OVERLOOK AT HOMESTEAD FILING NO. 1

FINAL PLAT

A PORTION OF THE NORTH HALF OF SECTION 27, TOWNSHIP 11 SOUTH, RANGE 64 WEST OF THE 6TH P.M., COUNTY OF EL PASO, STATE OF COLORADO

V1_Final Plat Drawings.pdf Markup Summary

DRAWN BY	JWT
CHECKED BY	ERF
H-SCALE	1" = 100'
JOB NO.	2422-00
DATE CREATED	06/05/24
DATE ISSUED	DRAFT
SHEET NO	2 OF 4

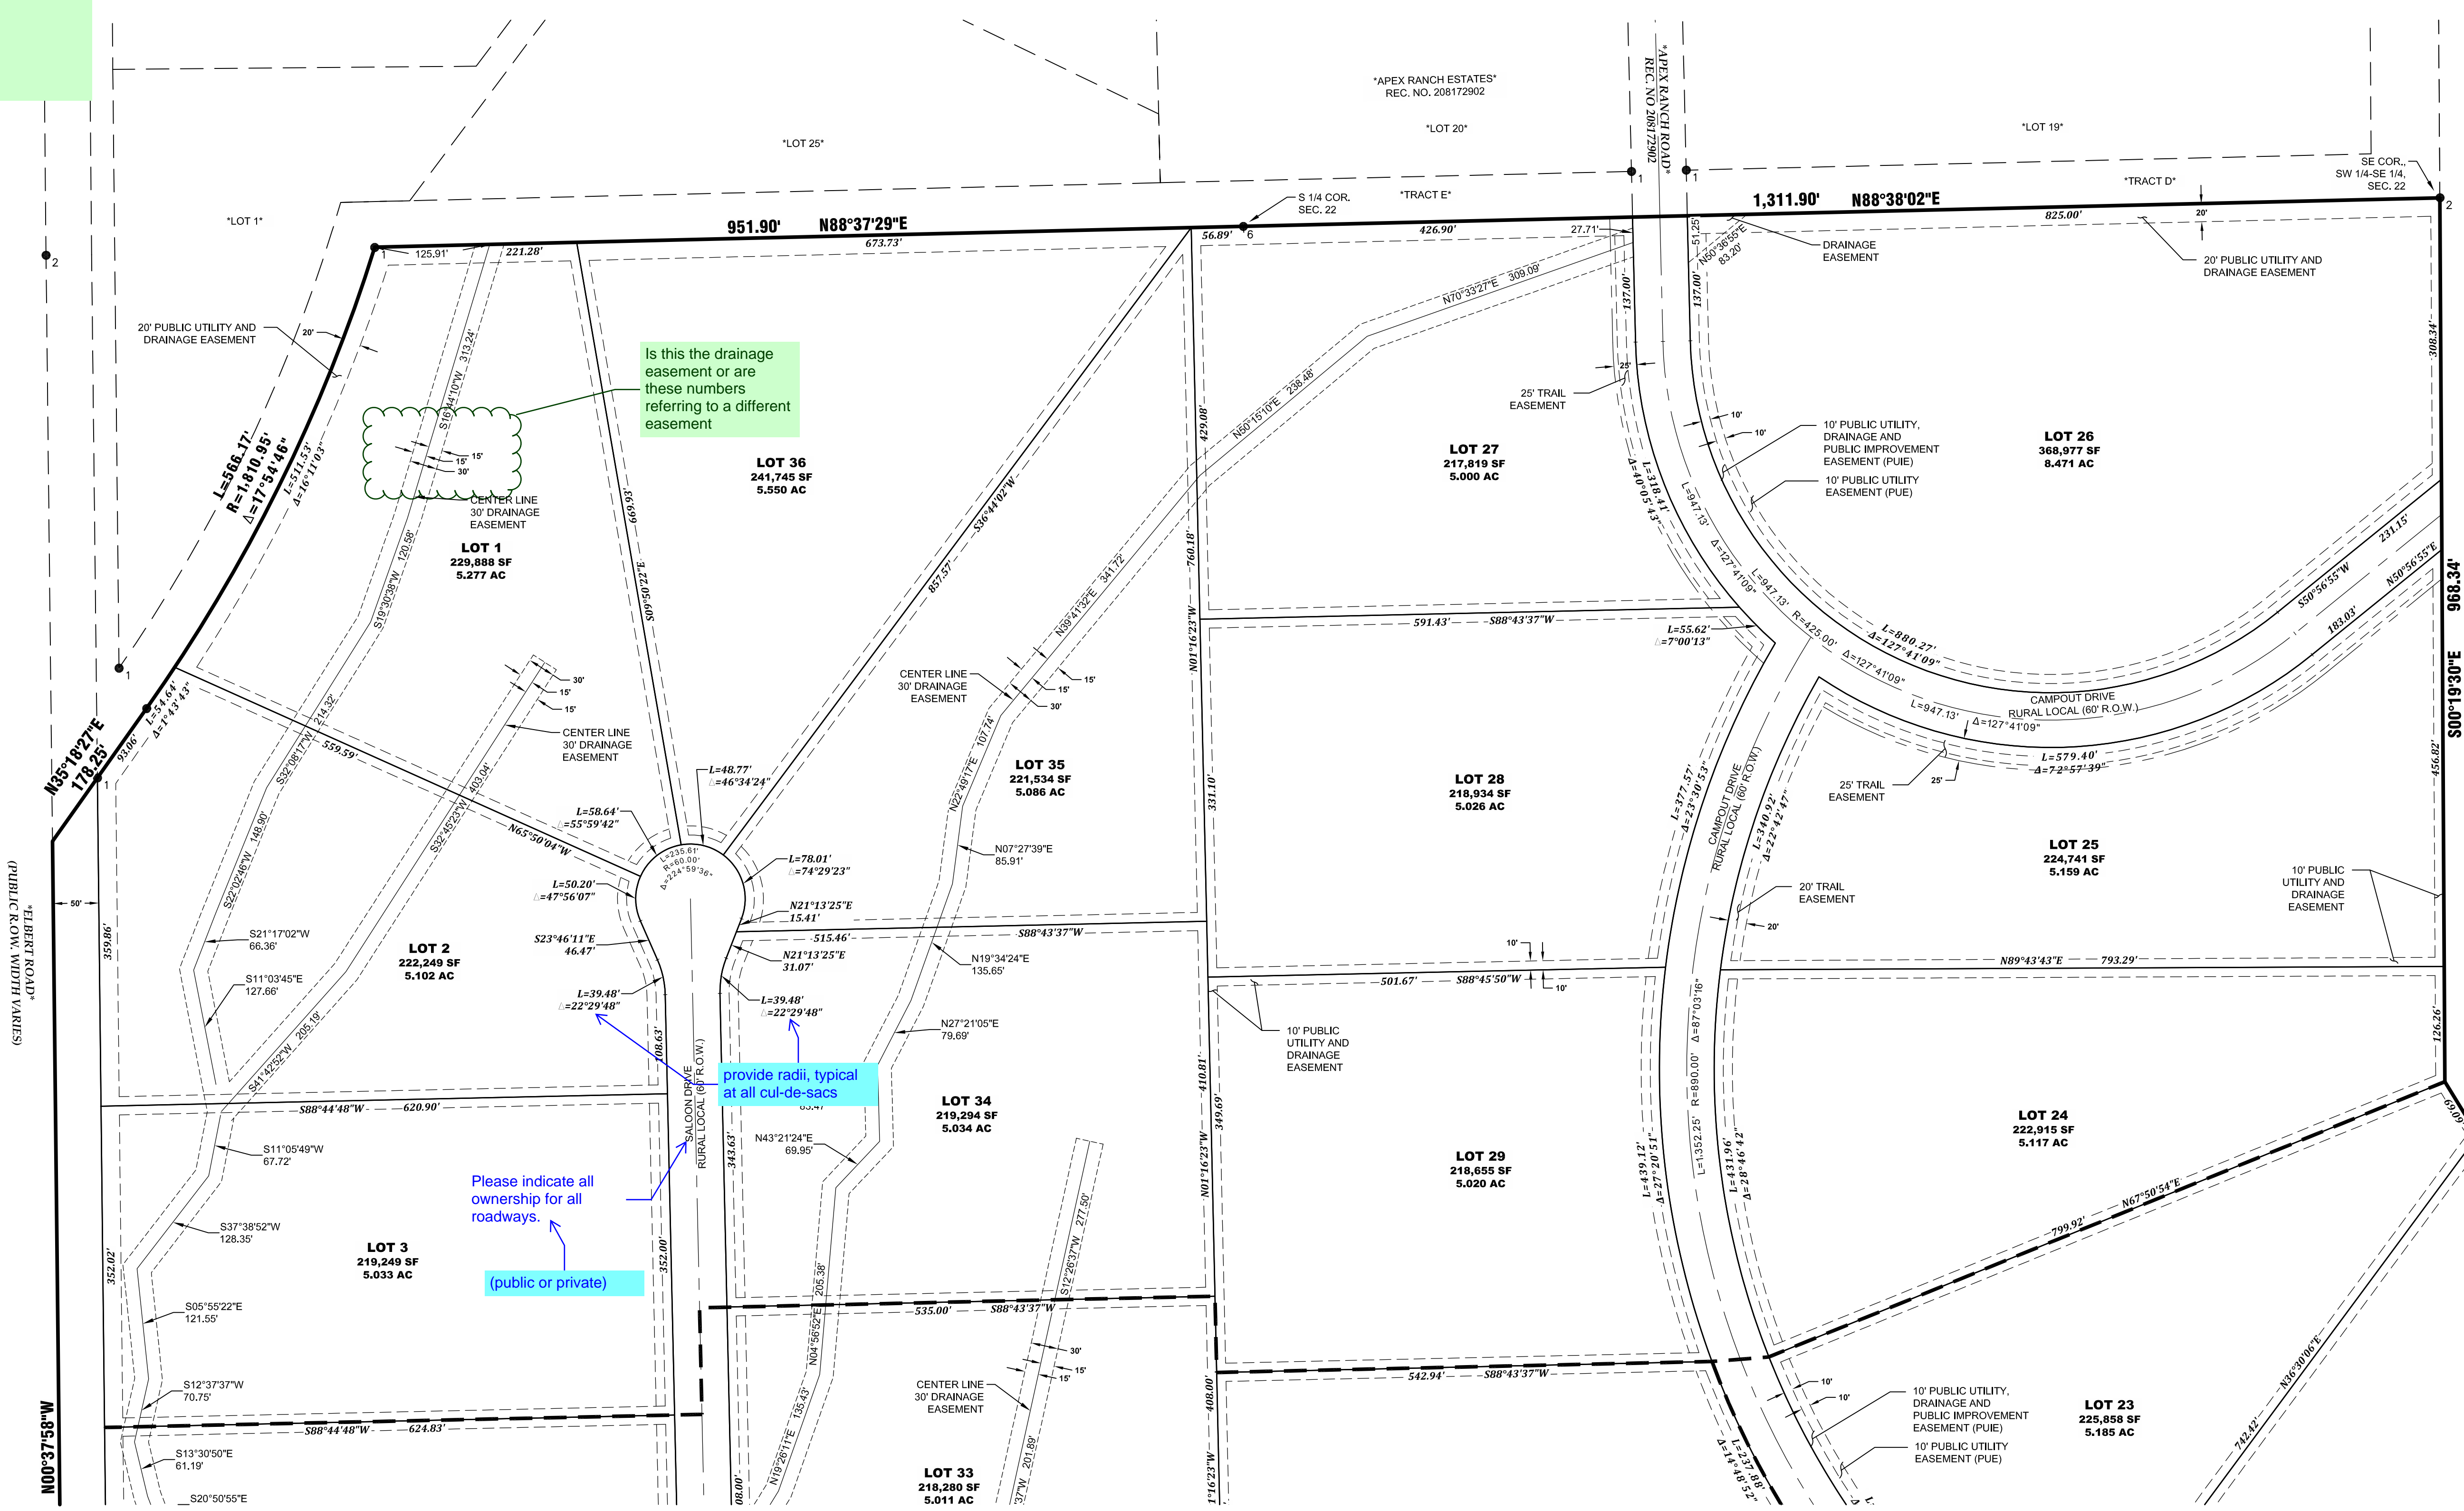
Have not received addresses
 Include addresses from PPRBD

Please provide match lines
 added

provide radii, typical at all cul-de-sacs
 radius added

Please indicate all ownership for all roadways.
 (public or private)
 public added

Will do when we get closer to approval. will add when addresses are available

DRAWN BY	JWT
CHECKED BY	ERF
H-SCALE	1" = 100'
JOB NO.	2422-00
DATE CREATED	06/05/24
DATE ISSUED	DRAFT
SHEET NO	3 OF 4

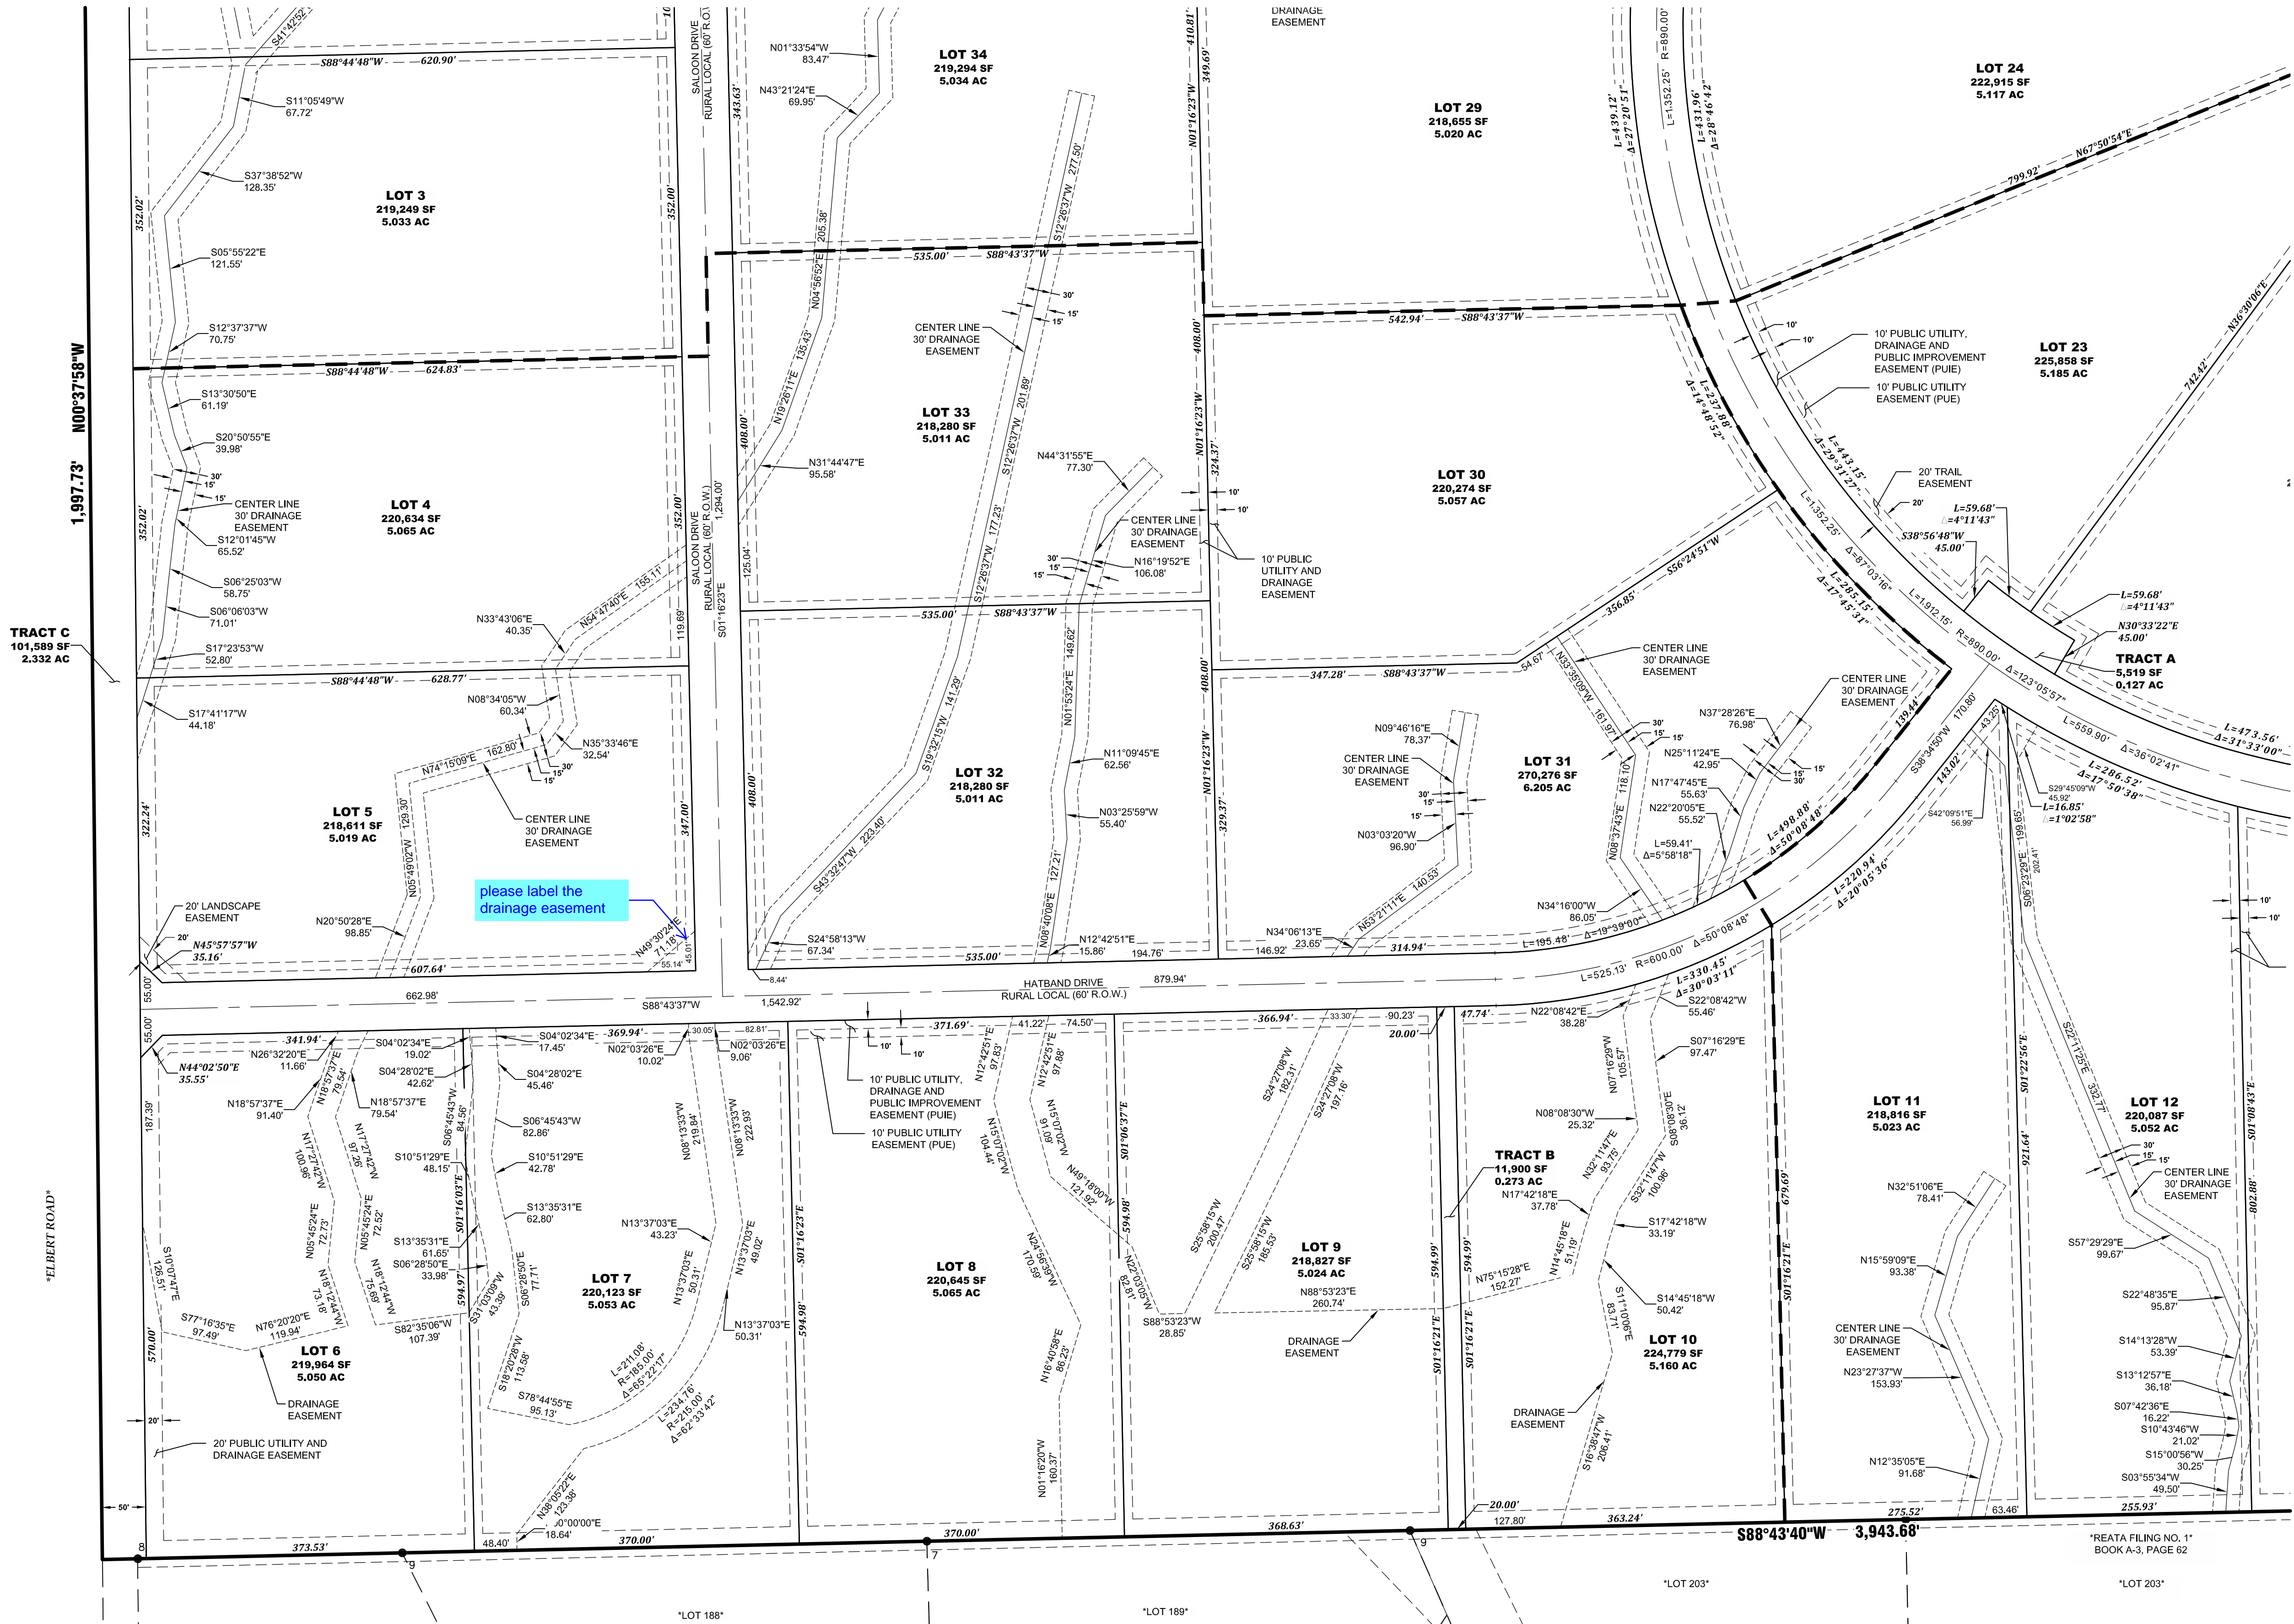
yes, the bearings, distances and dimensions are for the drainage easements for this plat
 Is this the drainage easement or are these numbers referring to a different easement

Yes, labeled as drainage easement?

DRAWN BY	JWT
CHECKED BY	ERF
H-SCALE	1" = 100'
JOB NO.	2422-00
DATE CREATED	06/05/24
DATE ISSUED	DRAFT
SHEET NO	4 OF 4

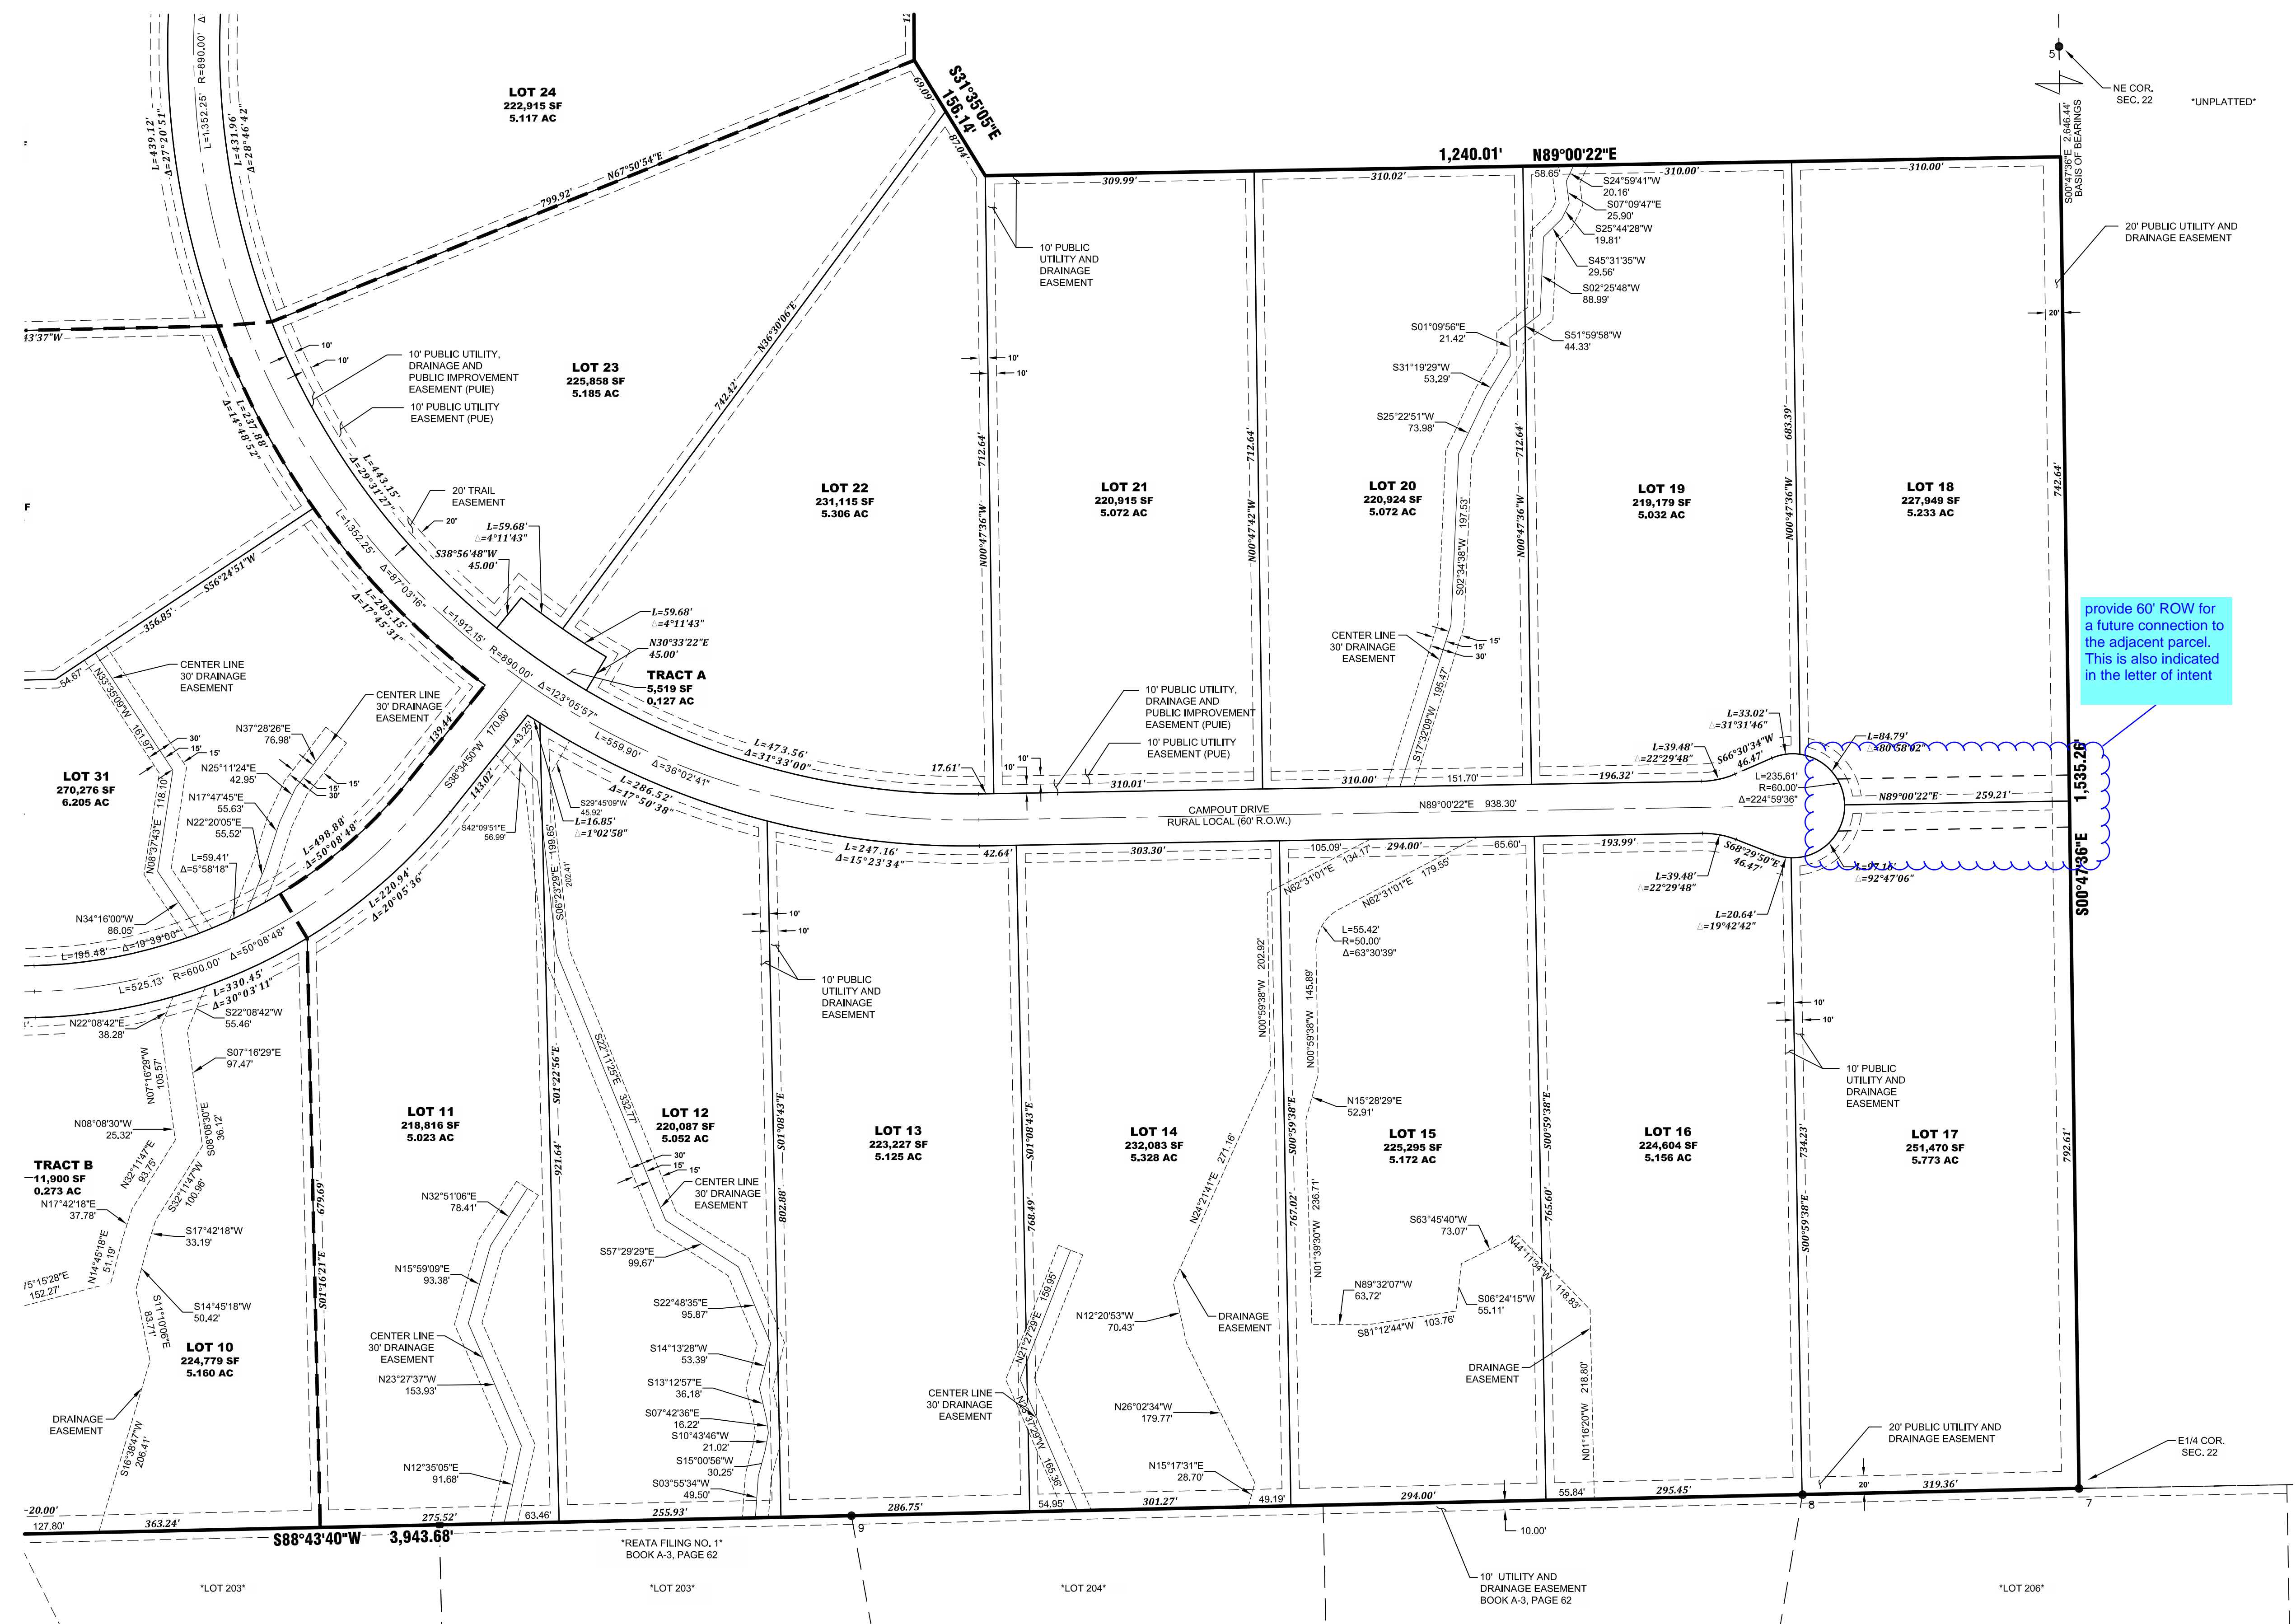
60' preservation area labeled
provide 60' ROW for a future connection to the adjacent parcel. This is also indicated in the letter of intent
